WESTMEAD CATHOLIC COMMUNITY EDUCATION CAMPUS APPENDIX A - RESPONSE TO SUBMISSIONS AND REQUEST FOR ADDITIONAL INFORMATION AND CLARIFICATIONS

CELC & ADMIN - EAST ELEVATION
MARCH 21 - EXISTING

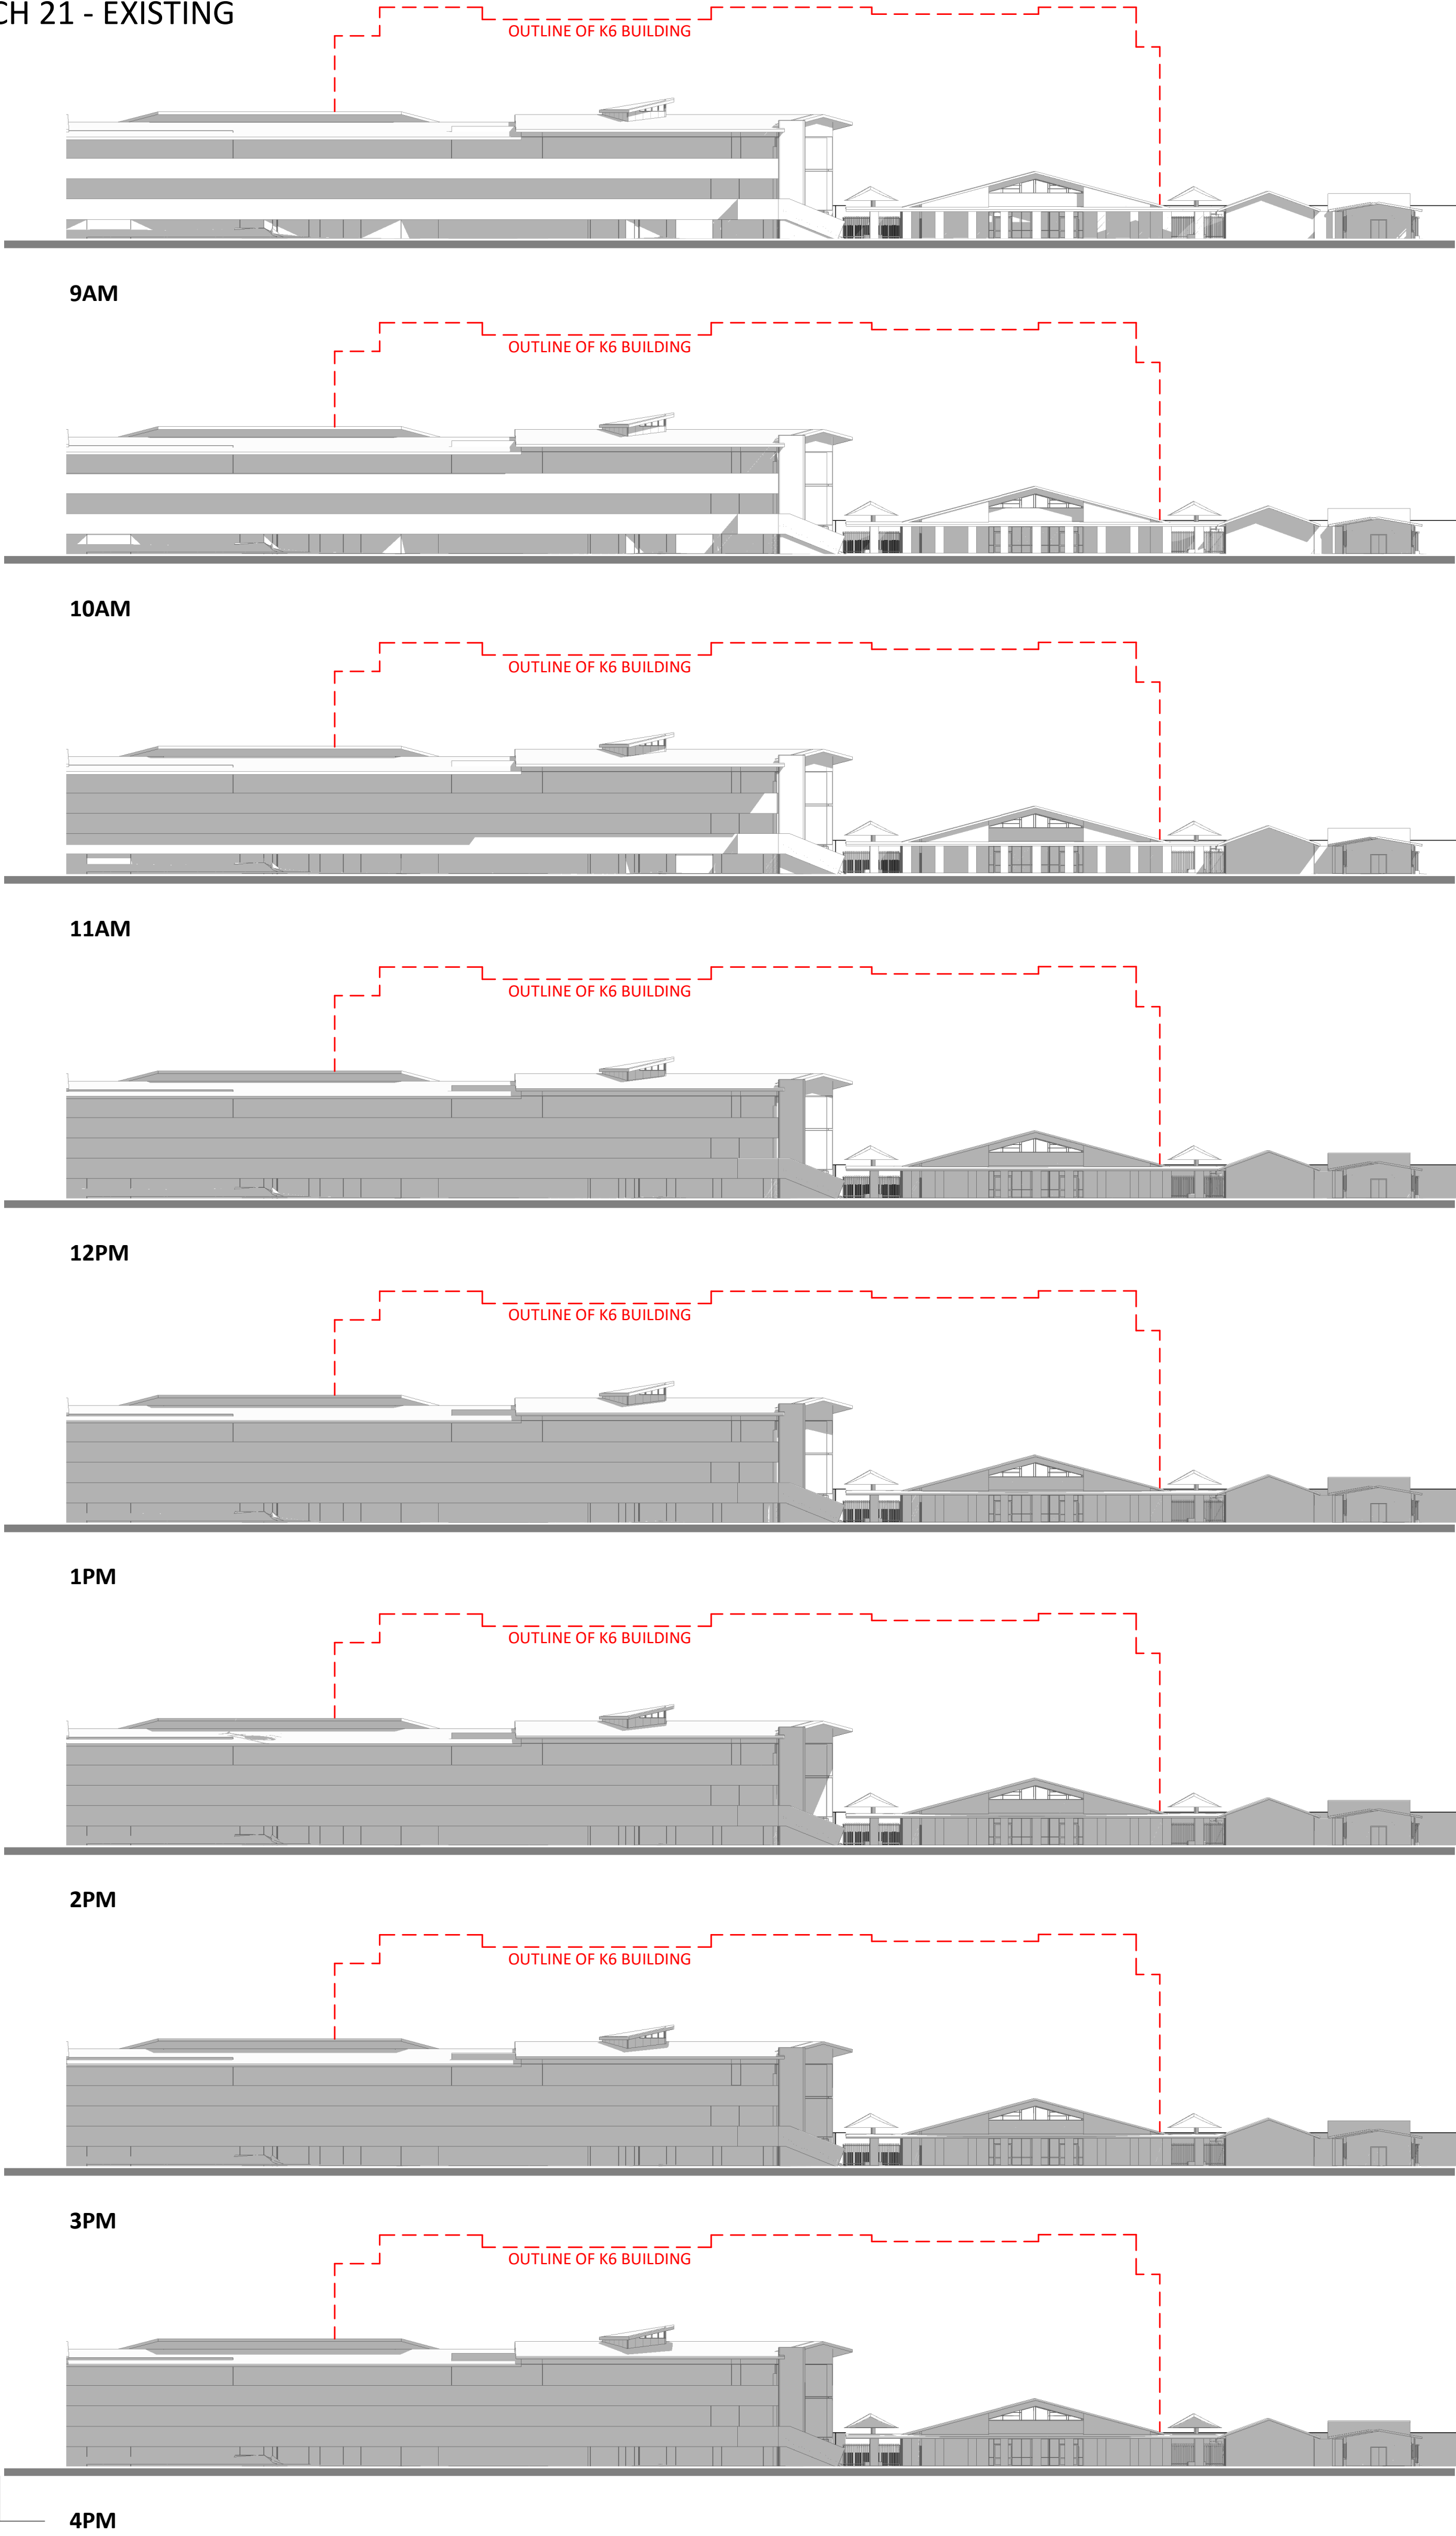
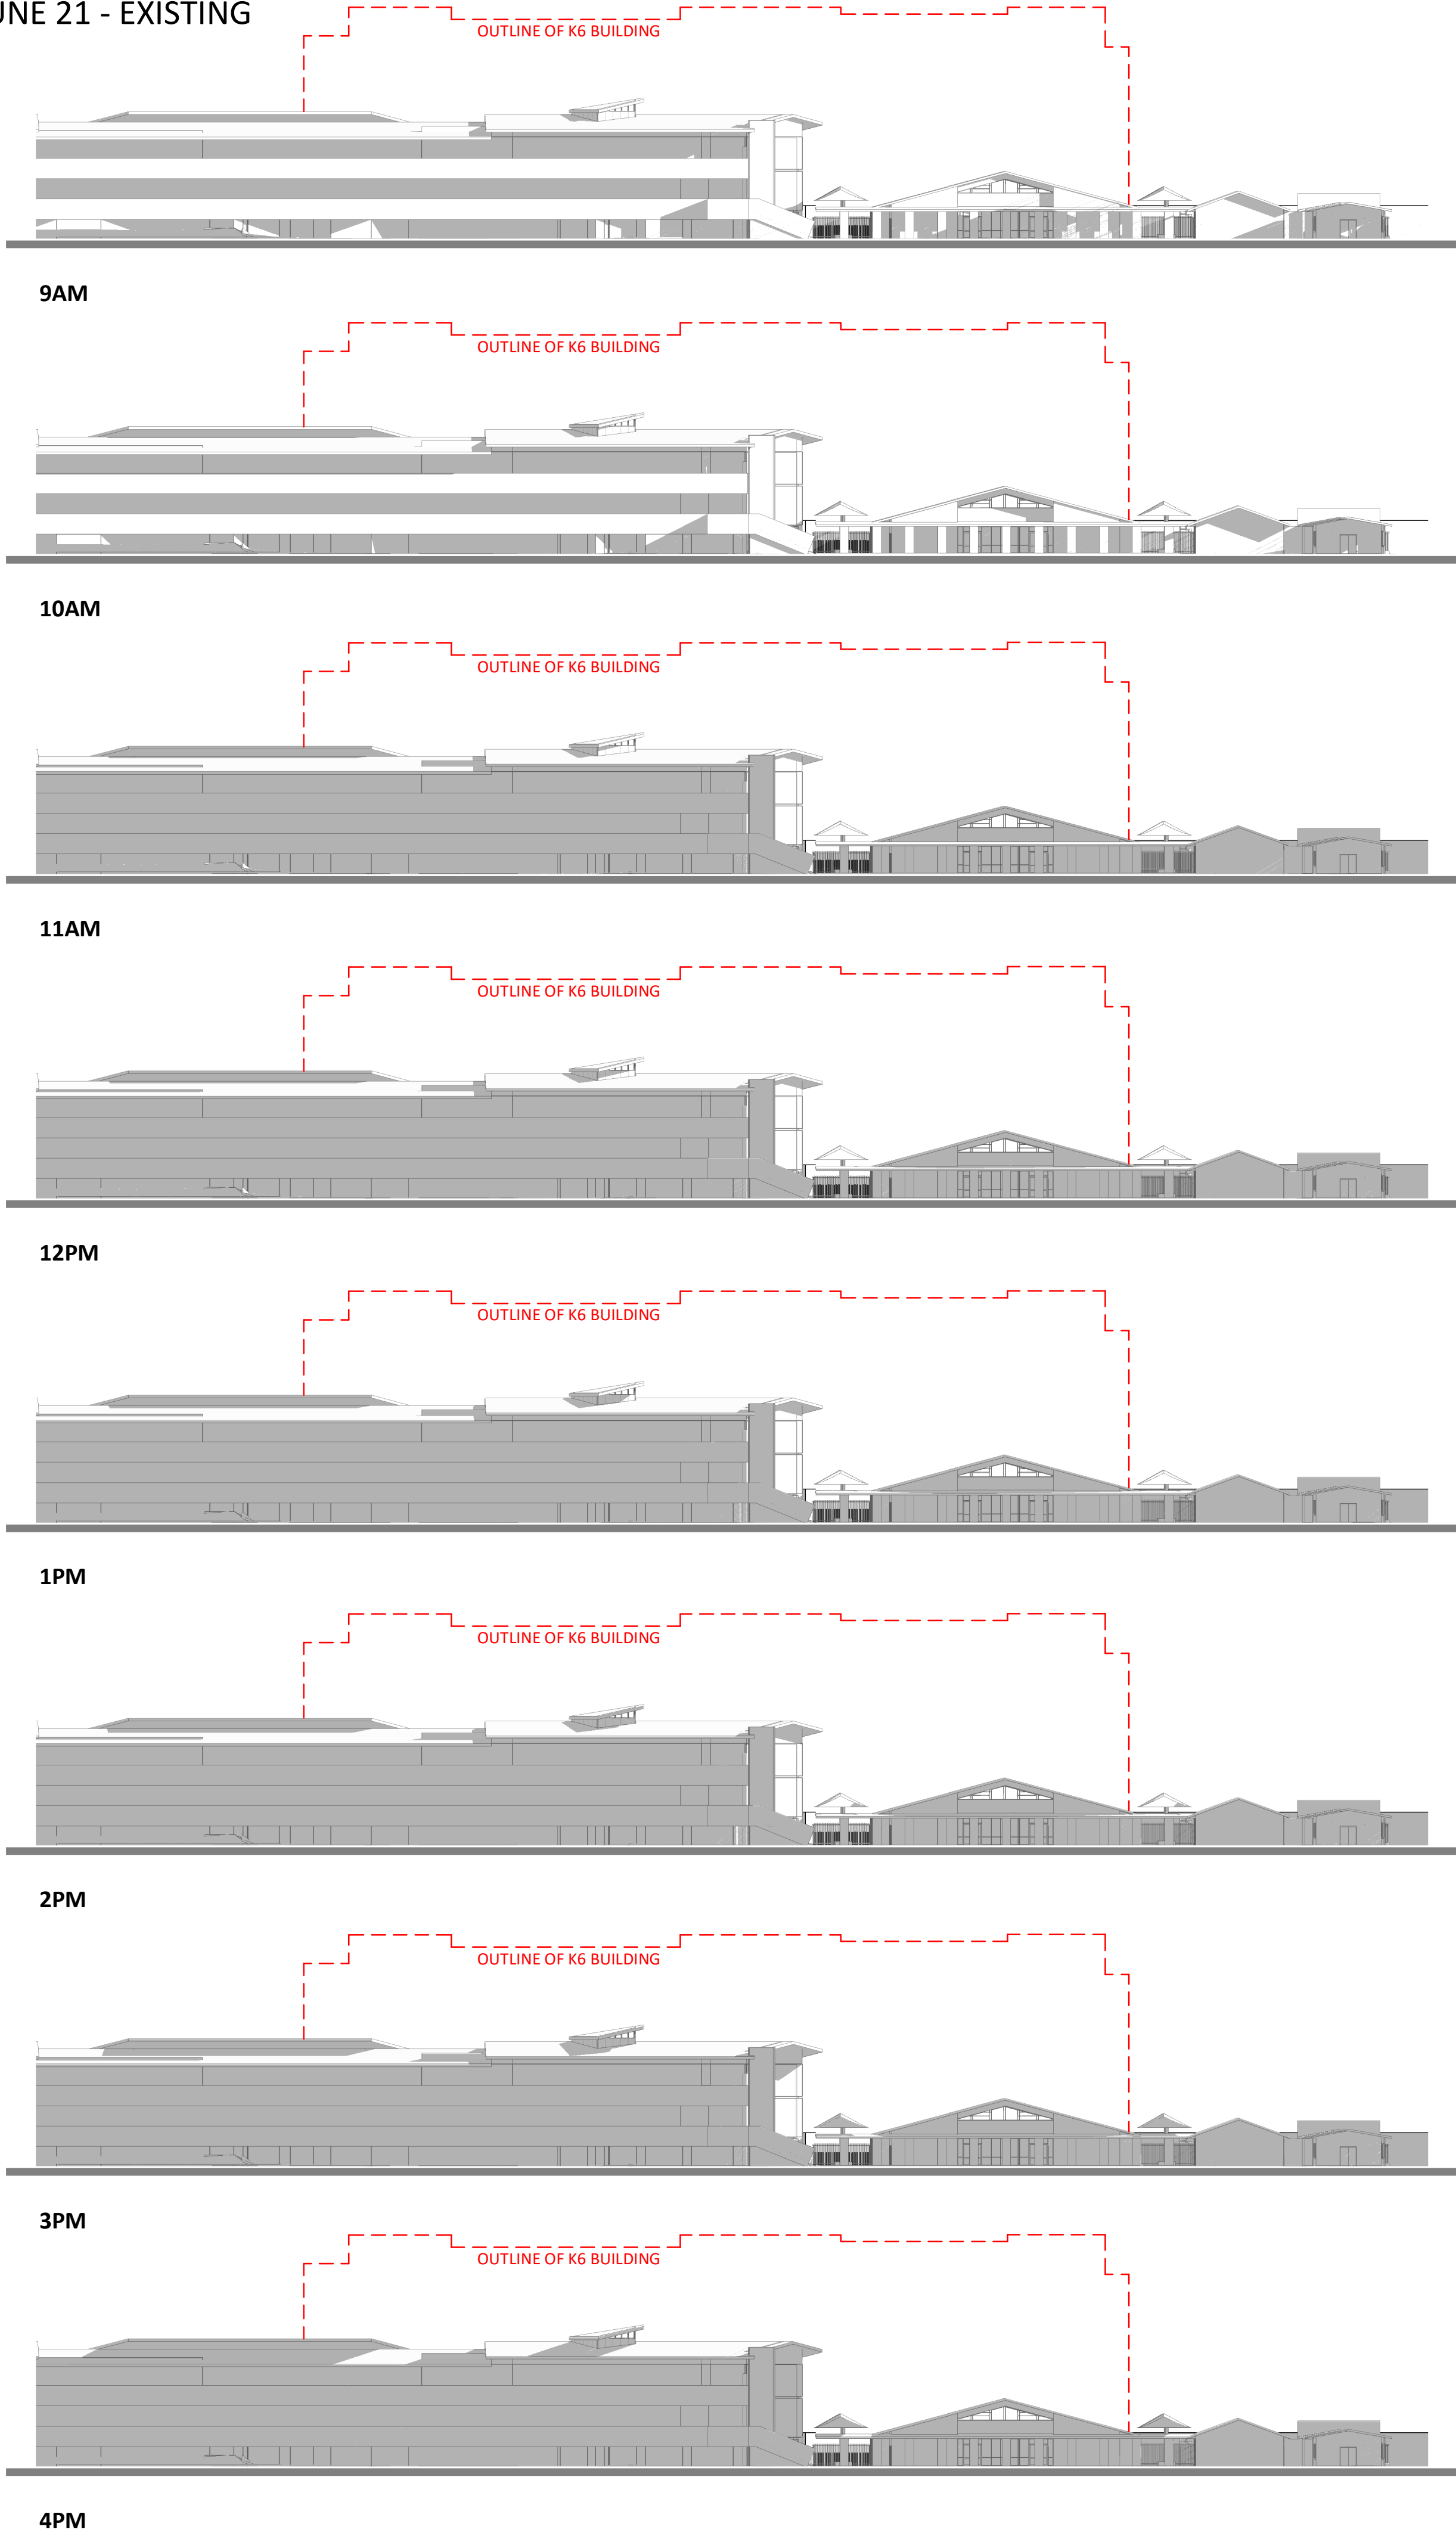
27			<p><u>Shadow diagrams</u> Hourly elevational shadow diagrams are to be provided for the proposed development during the winter solstice to assess the impacts of the primary school building on the façade of the childcare centre / administrative building.</p>	<p>Additional Shadow Diagrams have been prepared and are provided at Appendix B.</p> <p>The diagrams show that on the winter solstice, shadow impacts will be unchanged in the morning period. After midday, the proposed building will cause additional overshadowing of the CELC building.</p>

Item No	Name	Type	Issue	Response
				On the equinox, shadow impacts are largely unchanged until approximately 1pm. After 1pm, the proposed building will cause additional overshadowing of the CELC building. Whilst there be some additional overshadowing, this will not have a significant impact on the use of the existing building.
28			<u>Plans</u> The Submitted architectural plans do not clearly differentiate which parts of the ground floor of the primary school is covered and are within the building envelope. Therefore, revised architectural plans are to be submitted to clarify this.	This detail is shown on the revised Architectural Drawings at Appendix B .
29			The revised plans must include the outline of the roof over each floor to identify the covered open space area on each level.	This detail is shown on the revised Architectural Drawings at Appendix B .
30			<u>Photomontage</u> Photomontage of the proposed buildings in relation to the existing buildings on site, (preferably from various angles to cover all the buildings on site) should be submitted so that the relationship of the proposed development and the existing developments on the site can be assessed in detail.	Additional photomontages have been provided at Appendix I .
